**Consultation Response from KC,
Lead Local Flood Authority**

2023/92966 Land to the rear of, 271, Cliffe Lane, Gomersal, Cleckheaton, BD19 4SB

Demolition of existing dwelling and erection of 97 dwellings including formation of a new access from Cliffe Lane, landscaping, public open space and all associated infrastructure and engineering works

Date Responded: 25th October 2024

Client Quarters Gomersall			
Project Cliffe Lane Gomersall			
Drawing title Drainage Strategy - On Site			
Drawn RT	Chkd	Date FEB 24	Scale 1/500
Contract No. 23054-C-DR	Drg No. 0100	Revision P4

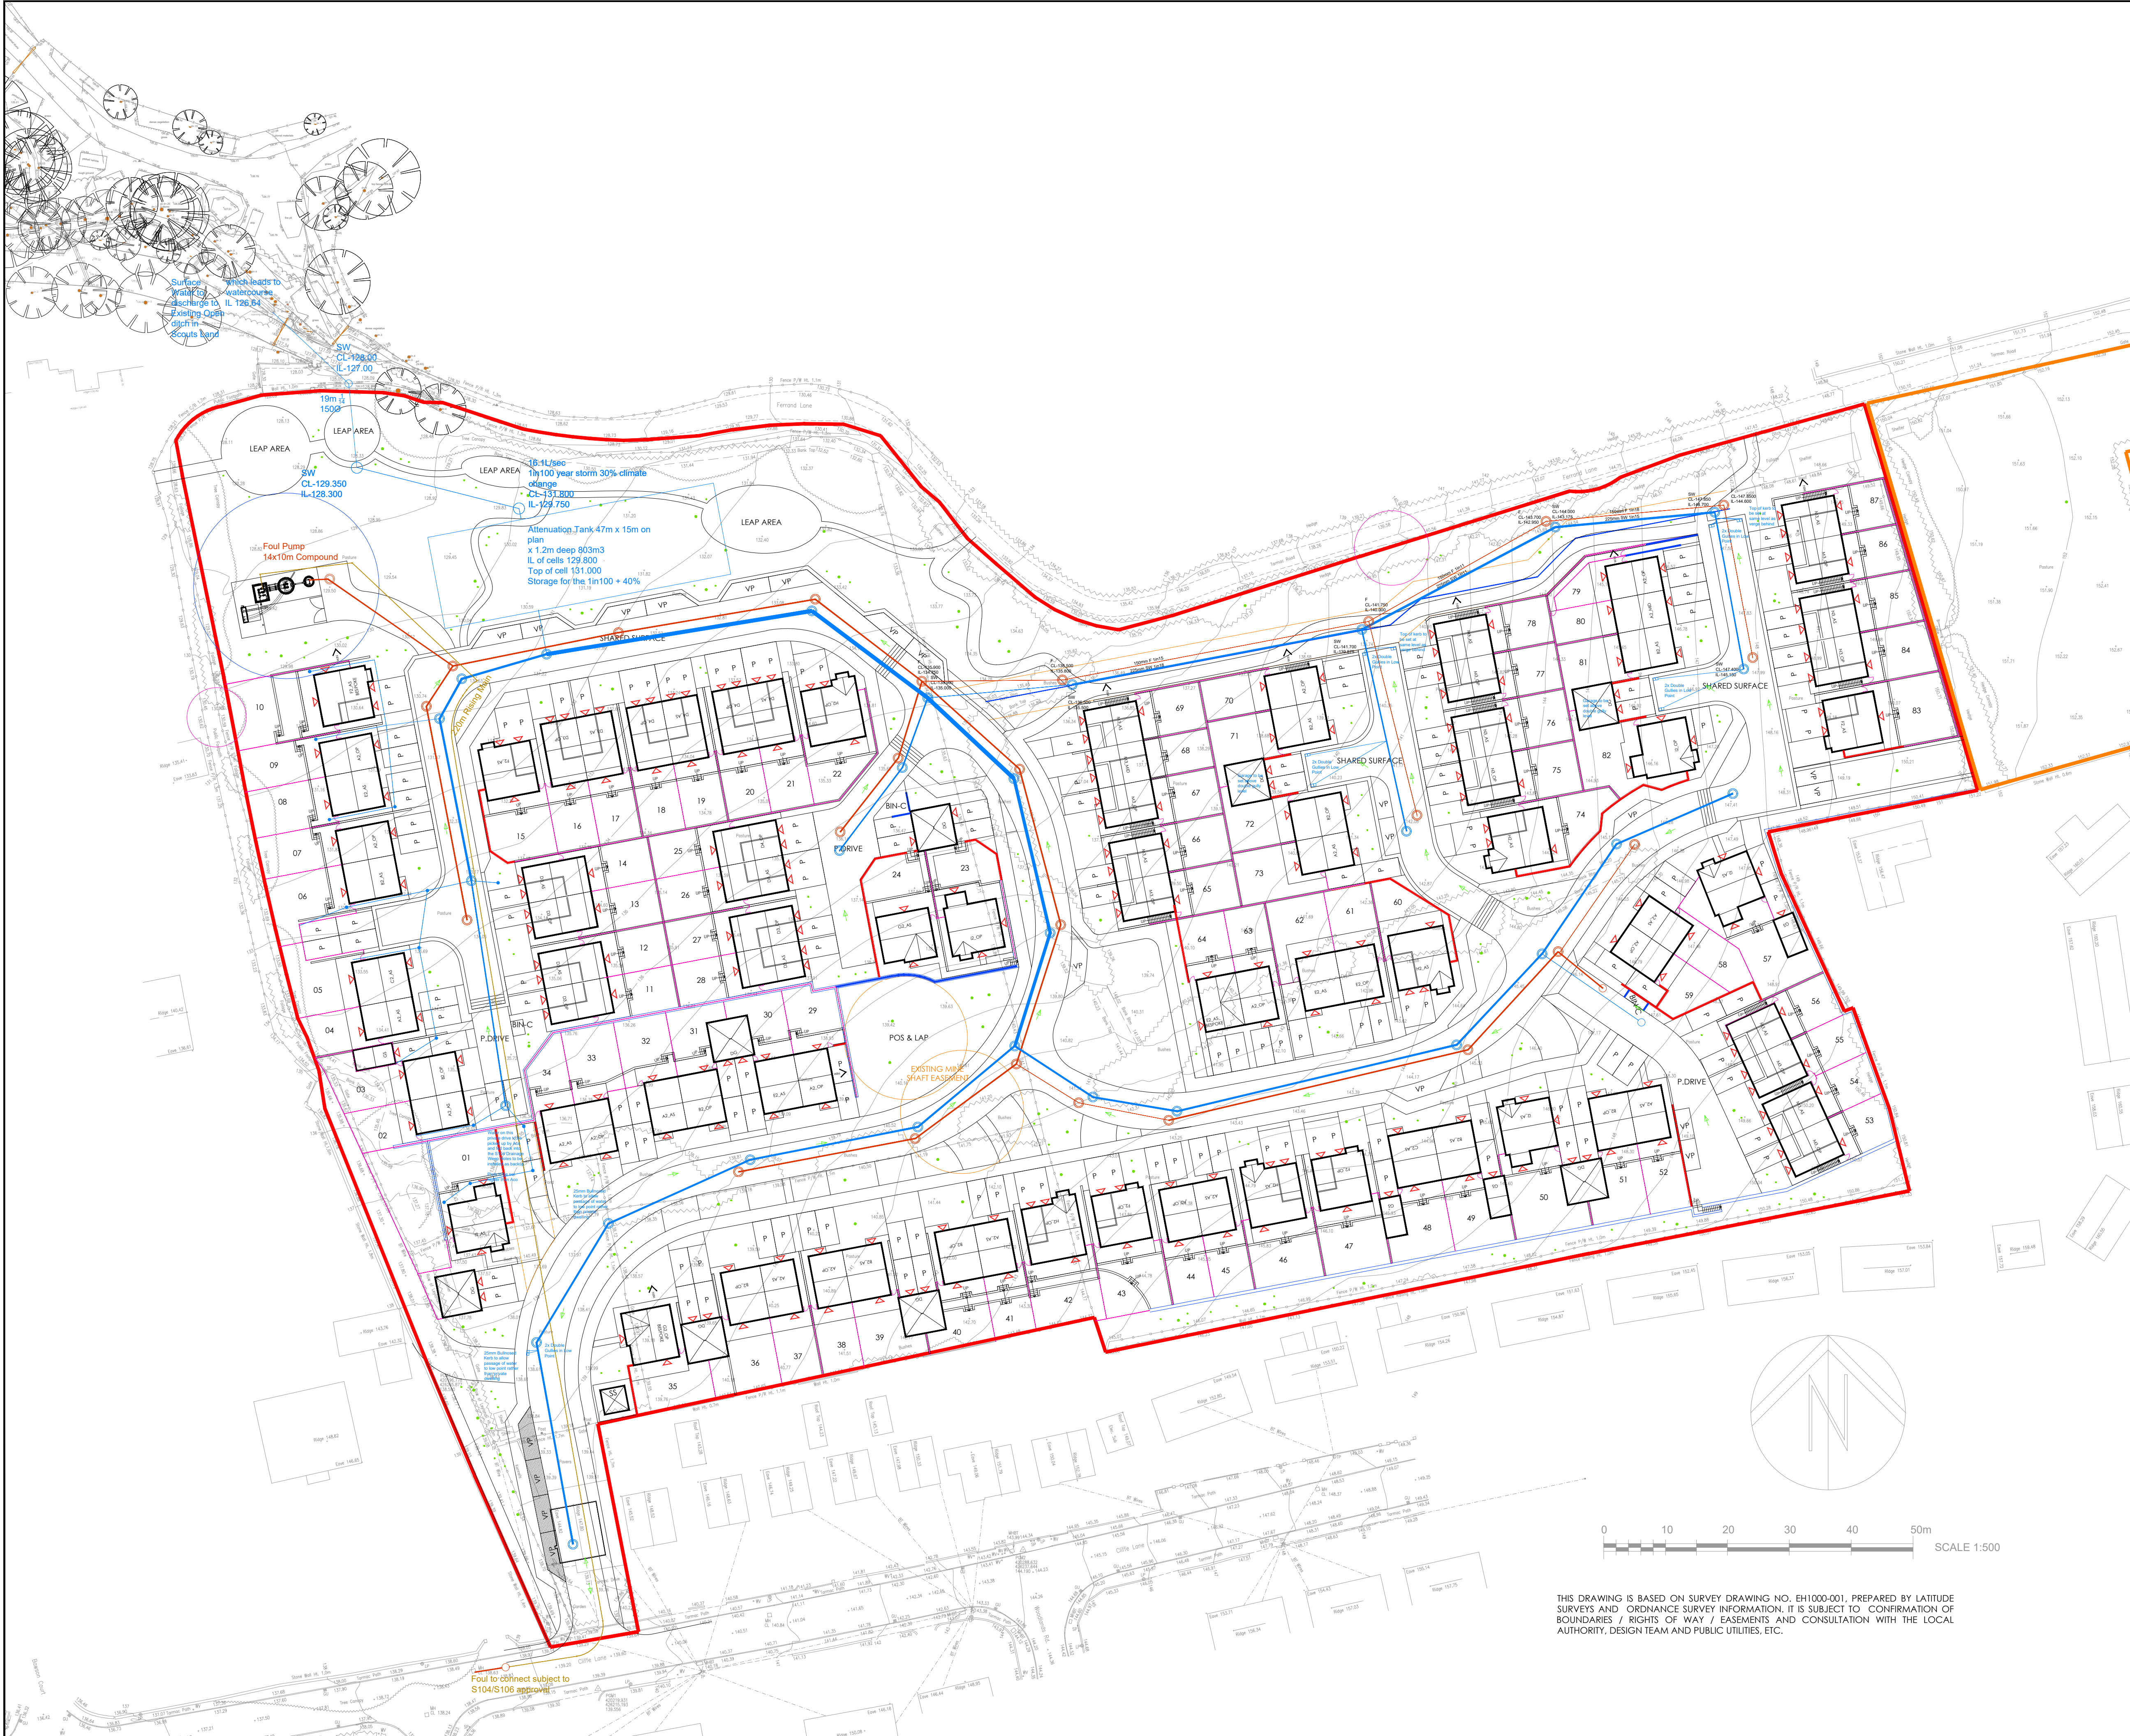
Crate storage has been removed from the latest drainage plan (23054-c-dr-0100-p6). However, design and simulation modelling does not appear to match with concrete tank shown on the drainage plan.
